CITY OF ALBUQUERQUE

July 17, 2019

RE: **Catalonia Subdivision**
Tr 1 & 2, The Trails Unit 3A
Drainage Report Stamp Date: 7/11/19
Grading Plan Stamp Date: 7/11/19
Hydrology File: C09D013

CATALONIA
OVERALL GRADING PLAN

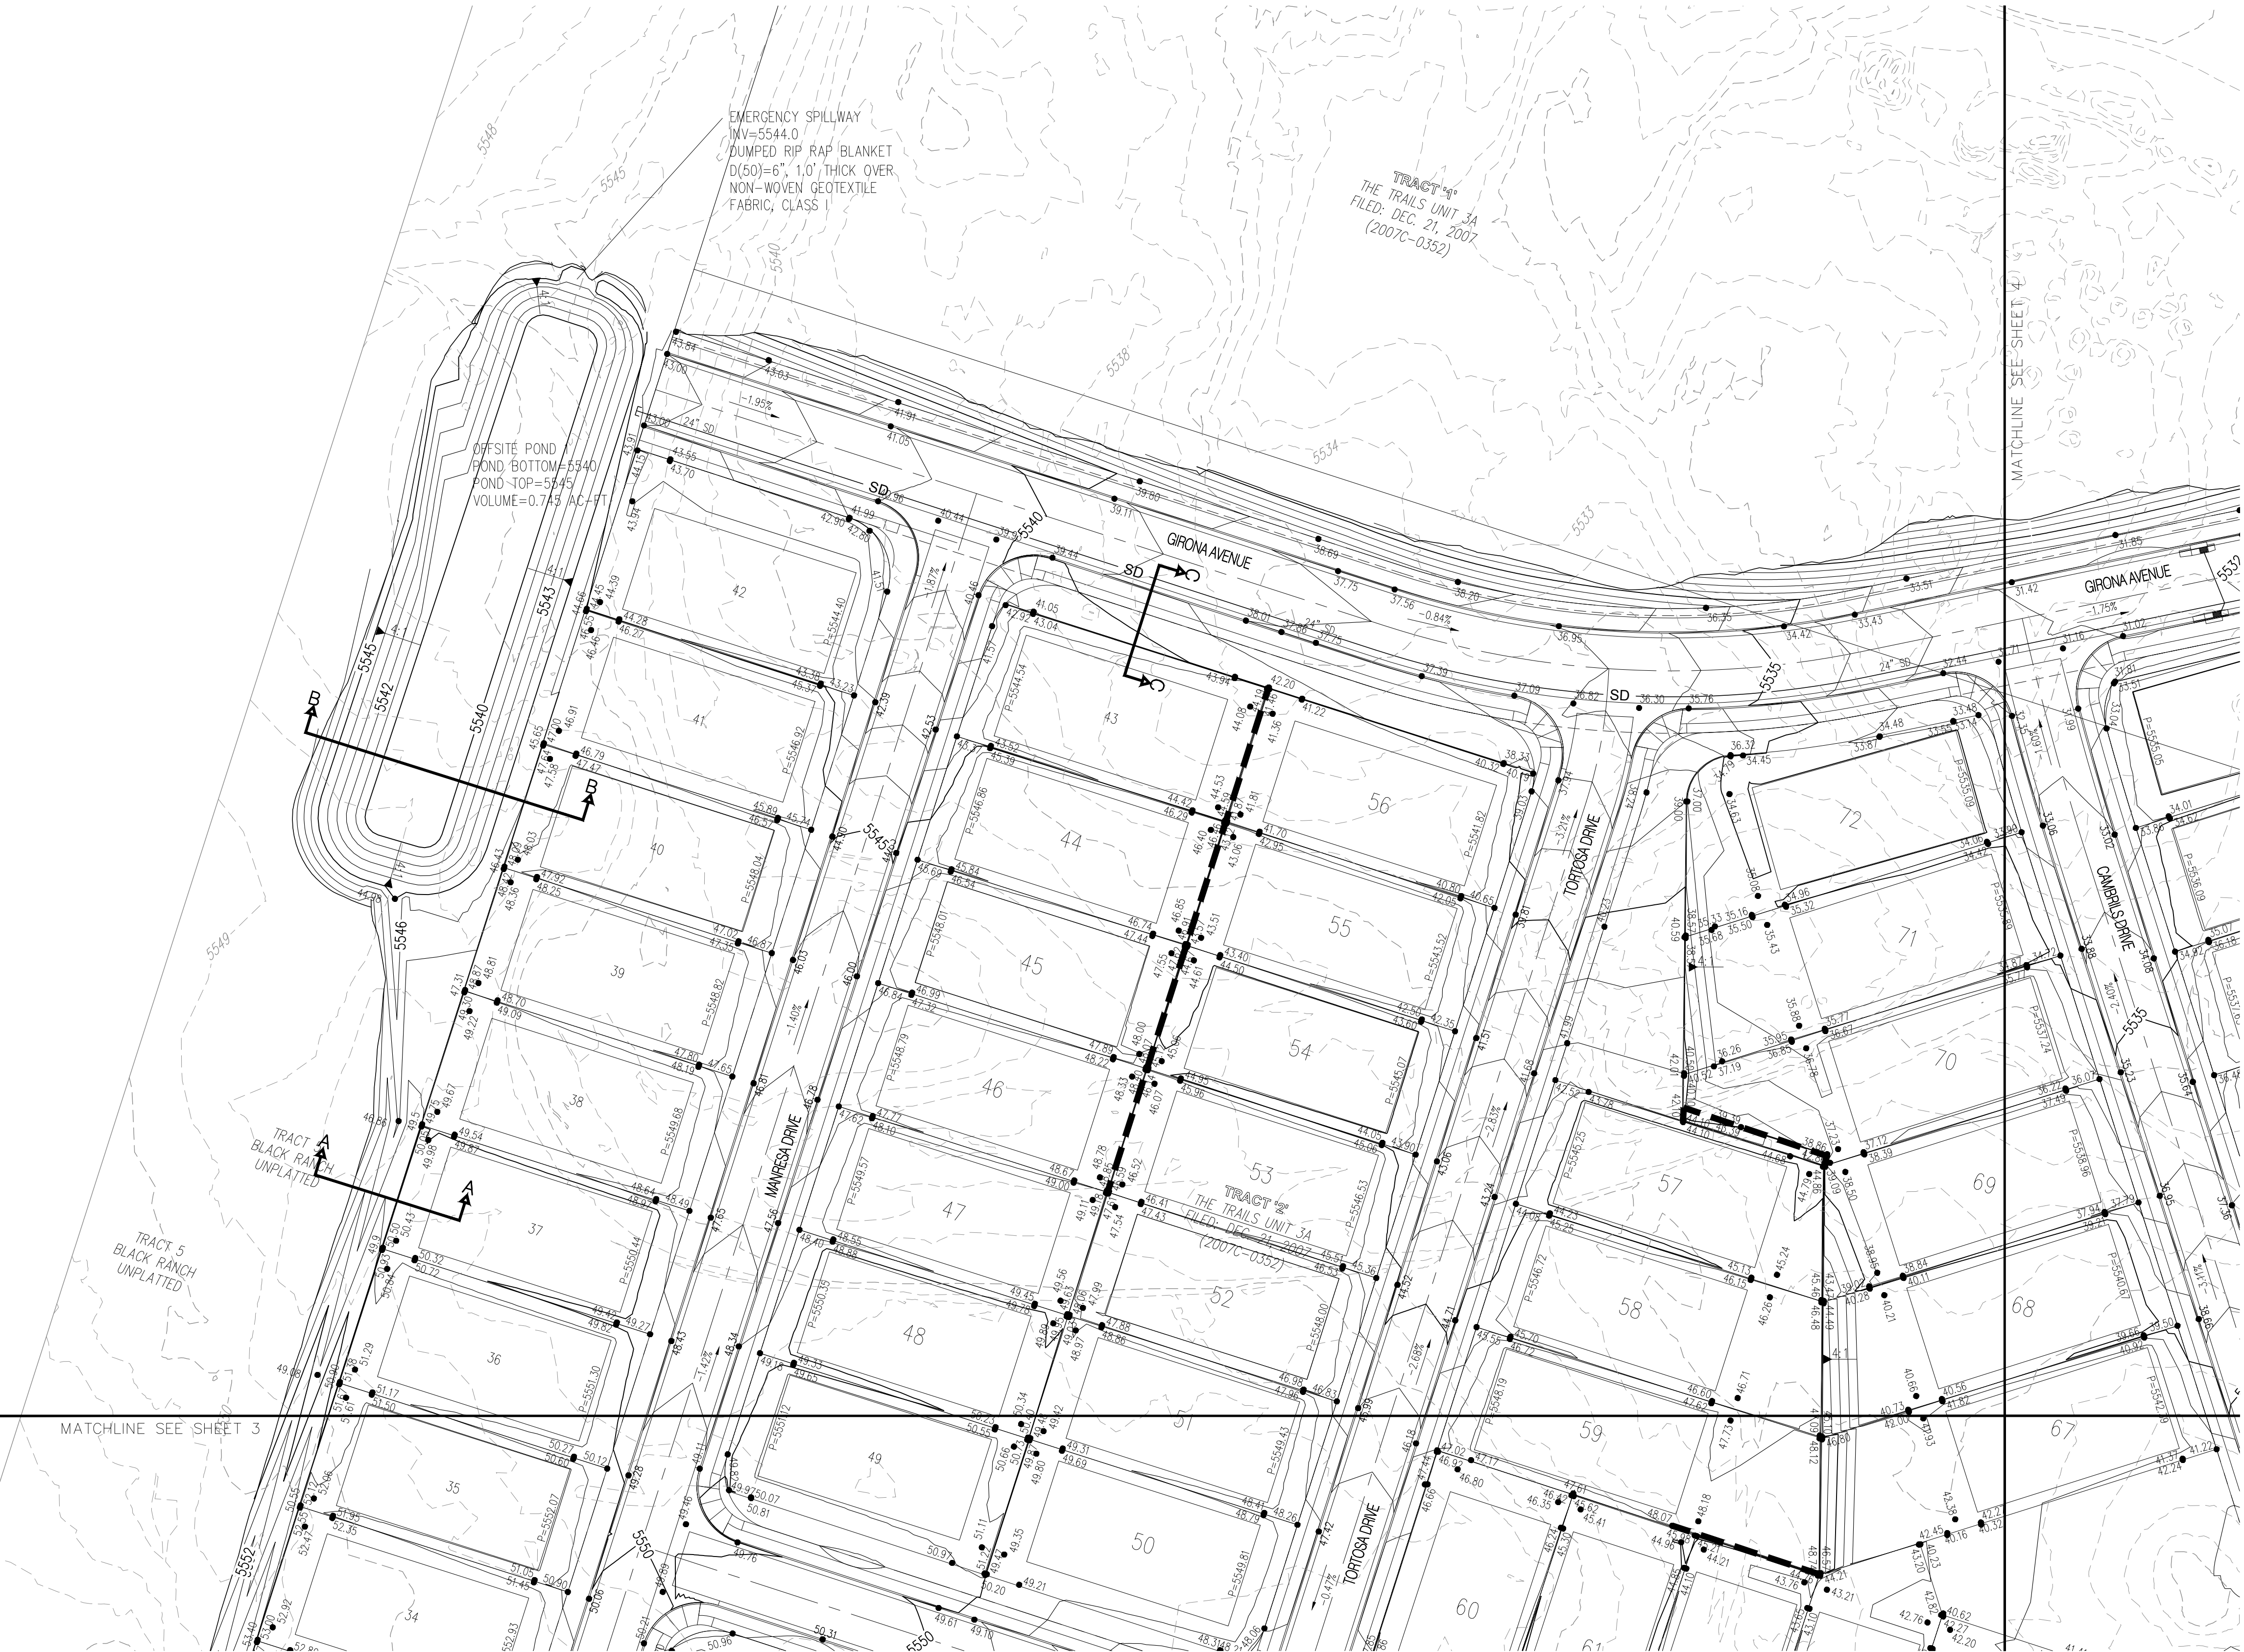
1. Offsite Pond 1.
 - a. Per The Trails DMP (Thompson, 2015) this pond ultimately needs to be 2.44 Ac-Ft. The proposed size (1.54 Ac-Ft) and the ultimate size need to be called-out on the Drainage Report, Grading Plan, and Work Order Plans. In the drainage report, add explaining language that when the development to the north comes in, it'll need to divert its offsite flows south into Offsite Pond 1 and upsize it from 1.54 Ac-Ft (not 1.08 Ac-Ft) to 2.44 Ac-Ft.

CITY OF ALBUQUERQUE DEPARTMENT OF MUNICIPAL DEVELOPMENT	
CATALONIA GRADING PLAN			
DESIGN REVIEW COMMITTEE	CITY ENGINEER APPROVAL	LAST DESIGN UPDATE	MO./DAY/YR.
CITY PROJECT NO.	ZONE MAP NO. C-08	SHEET 3	OF 3

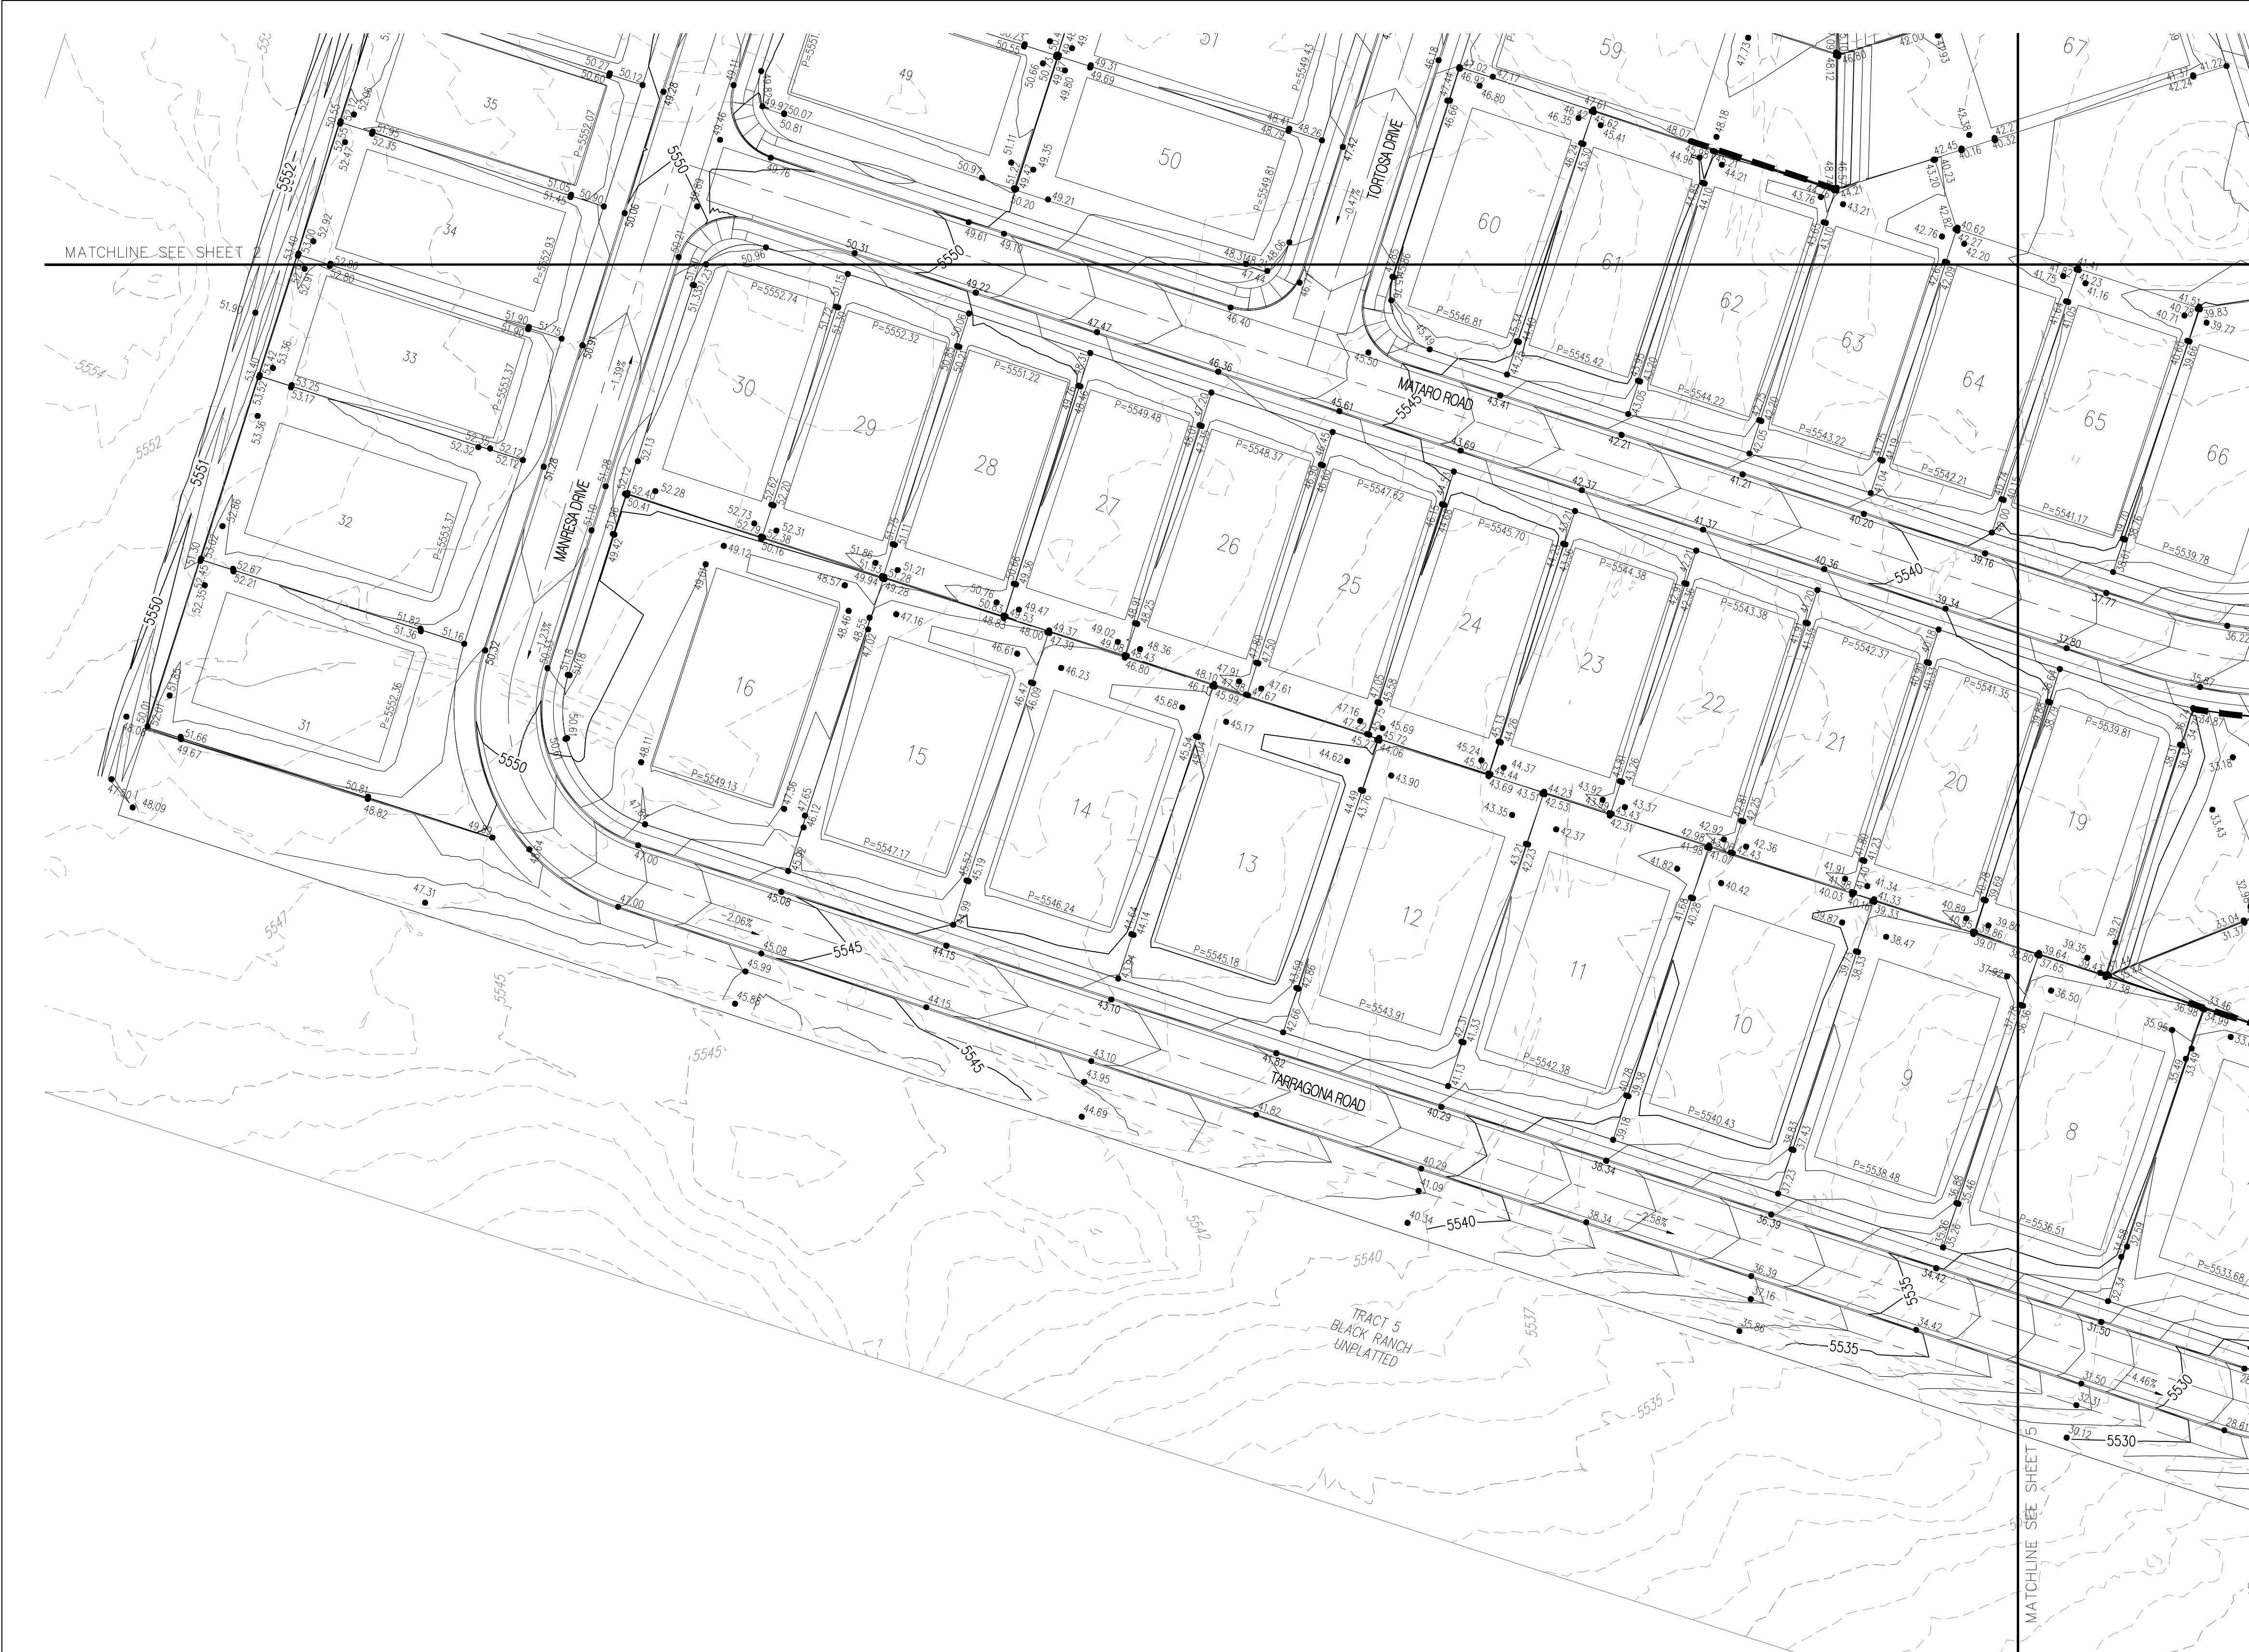
- b. Show and label the 100-yr WSE and SWQV elevation of each pond on the grading plan.
3. Storm Water Quality (SWQ). Use of Retention Pond A5 and Pond A for retaining the SWQV acceptable provided that the SWQ volume and SWQ water surface elevations are called out on the plans and in the maintenance covenants. The SWQ retention within these ponds will be permanent.

4. Please look at the Cambrils Dr assembly/section in front of lots 1-5. The contours seem to show an inverted crown with an odd transition in front of lot 6.
